Development Facilitation Team (DFT) – Review Comments

Project No: PR-2023-008608 Date: 03/27/2023 Agenda Item: #5 Zone Atlas Page: E-10

Project Name: Formalization of Vacation of Utility Easement at 8035 Kibo Dr. NW

Preliminary/Final Plat

**Plat for  
 Lot 12-A, Block 7  
 Volcano Cliffs Subdivision, Unit 5  
 Being Comprised of  
 Lot 12, Block 7  
 Volcano Cliffs Subdivision, Unit 5  
 City of Albuquerque  
 Bernalillo County, New Mexico  
 January 2024**

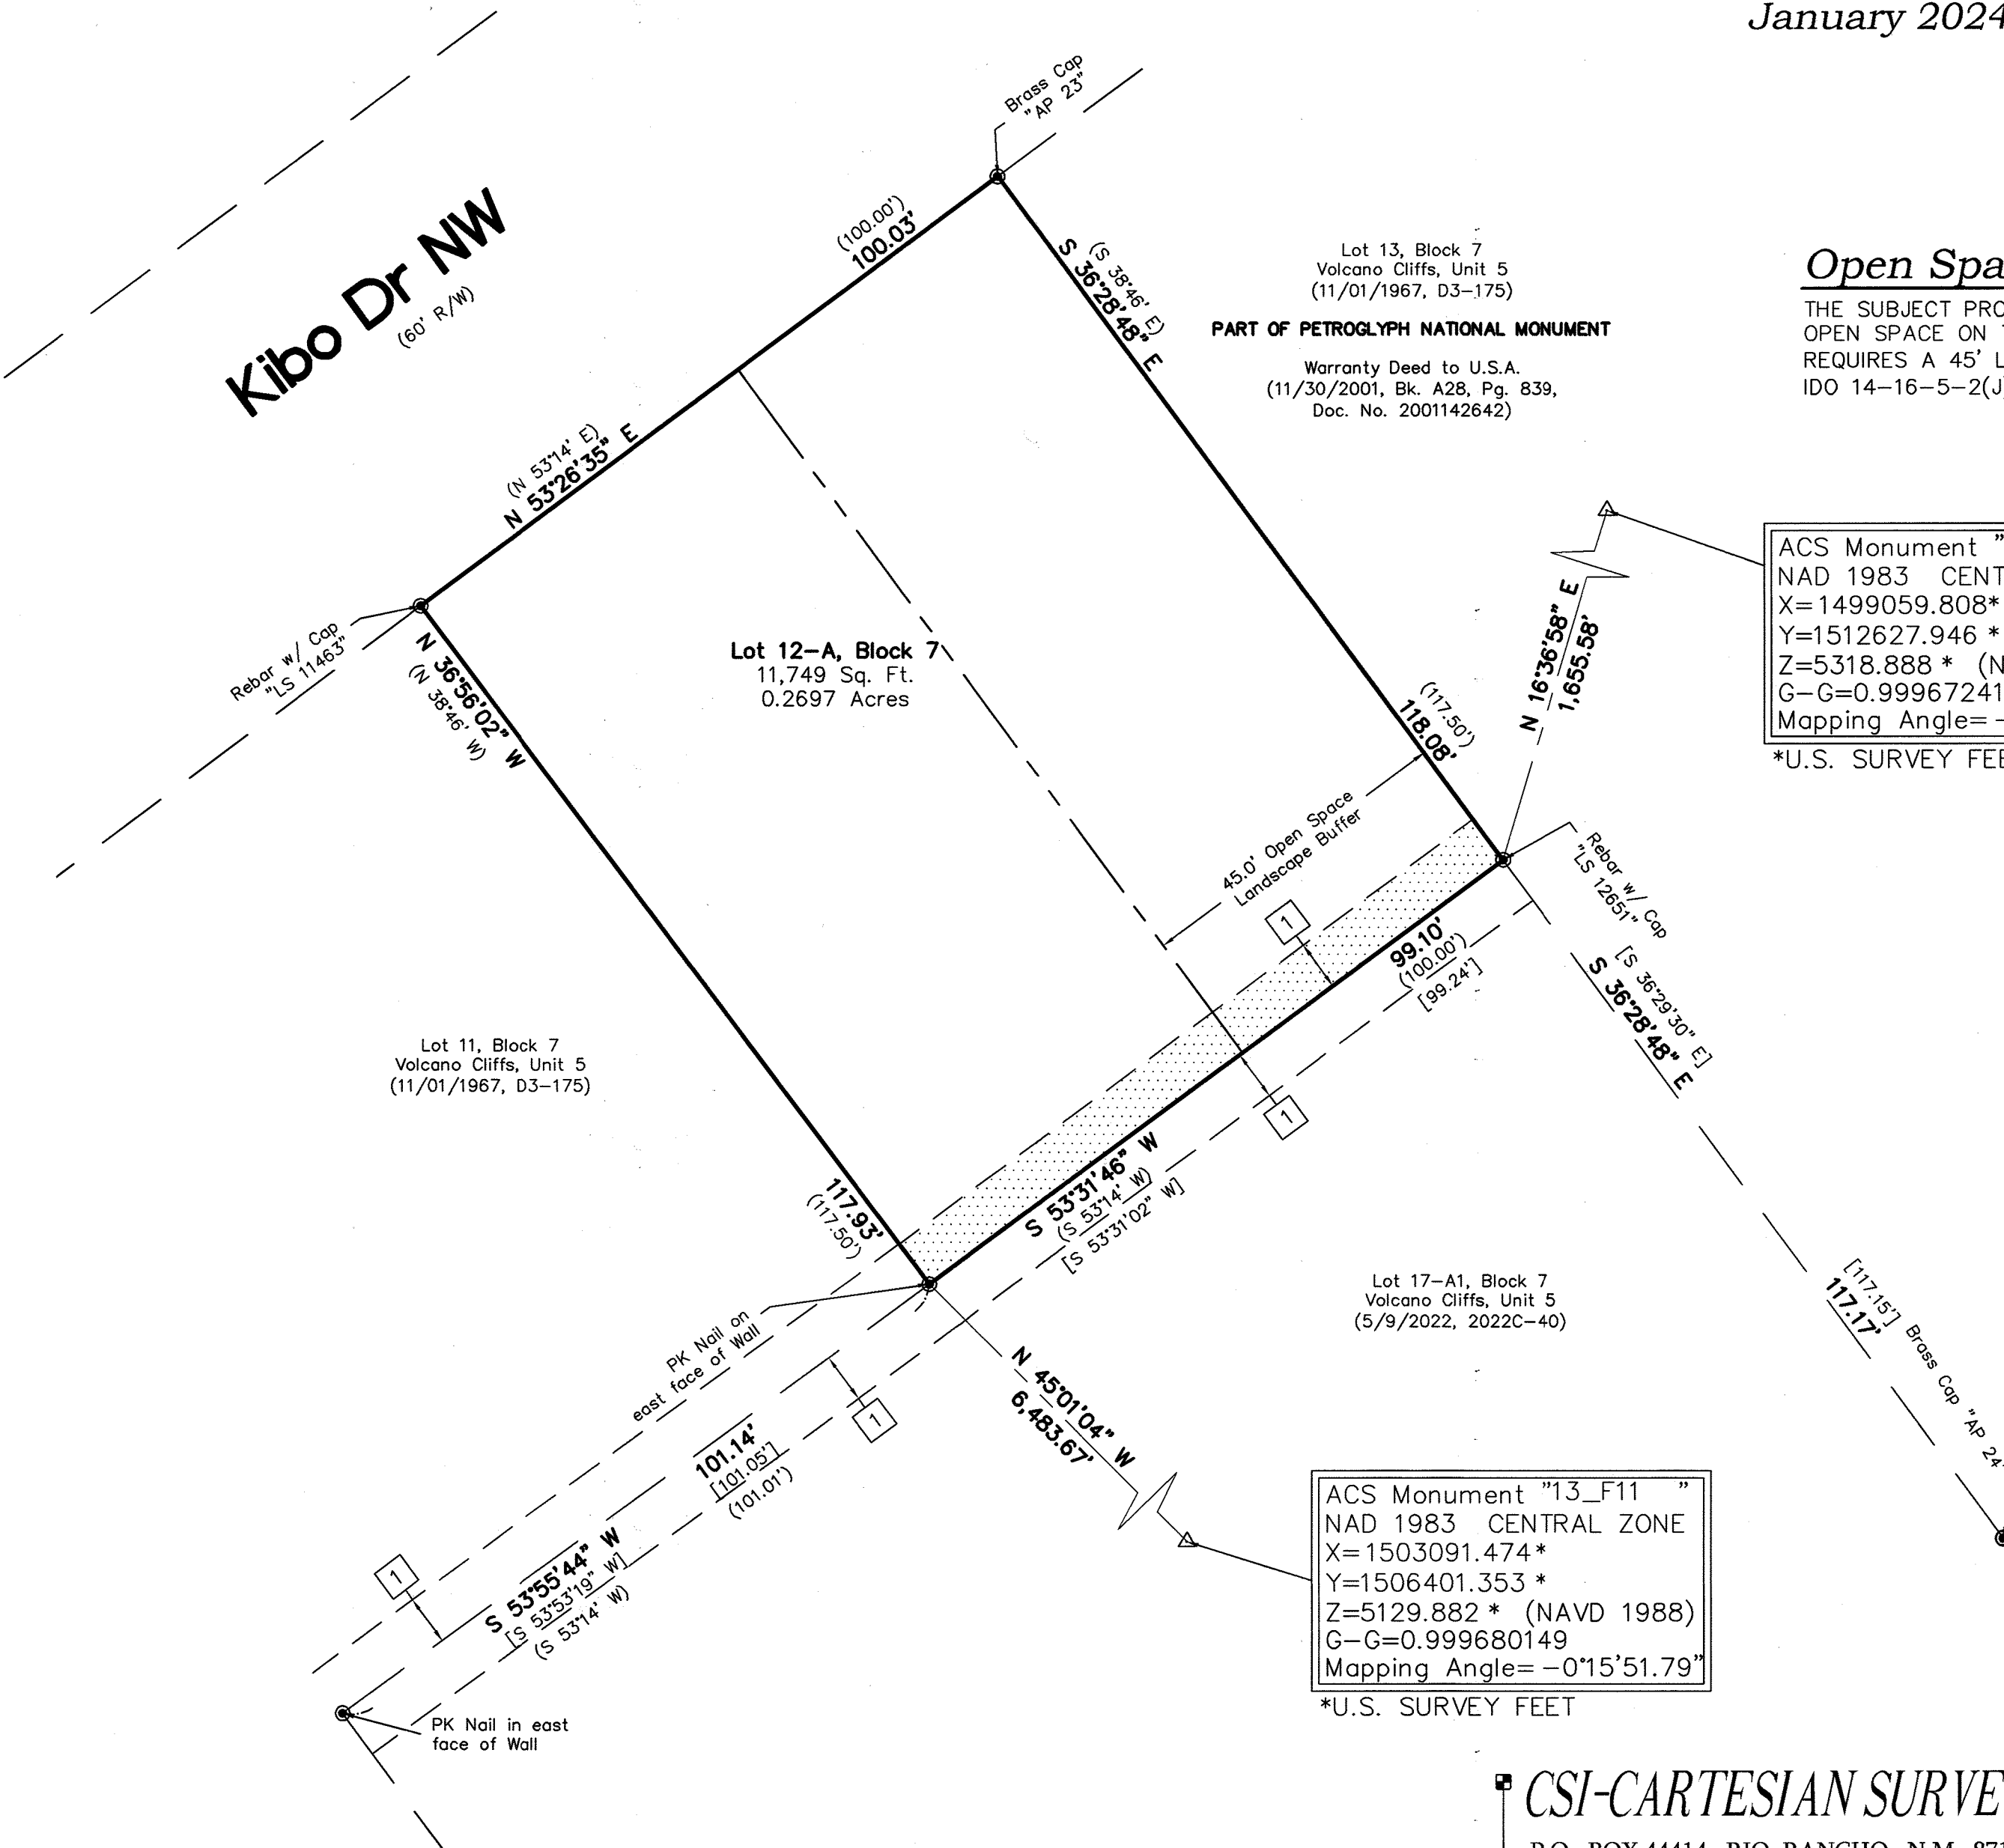
- The Plat needs to depict the 45-foot landscape buffer abutting the Major Public Open Space (NR-PO-B-zoned) abutting the eastern boundary of the subject property. The Open Space Superintendent will need to approve any landscaping in this area. No structures are allowed within the buffer unless they already exist, i.e., the existing house.

Please demonstrate compliance with the 45' Landscape buffer on the Plat.

- 5-1(G) Exceptions and Encroachments may encroach into a required setback, but in-ground swimming pools shall not be closer than 5 ft. from any lot line or building. Ensure pool is being construction 5' minimum from all lot lines.

The layout on the Plat does not match the building permit issued for the pool construction. Please confirm that this standard is being met and annotate on the Plat.
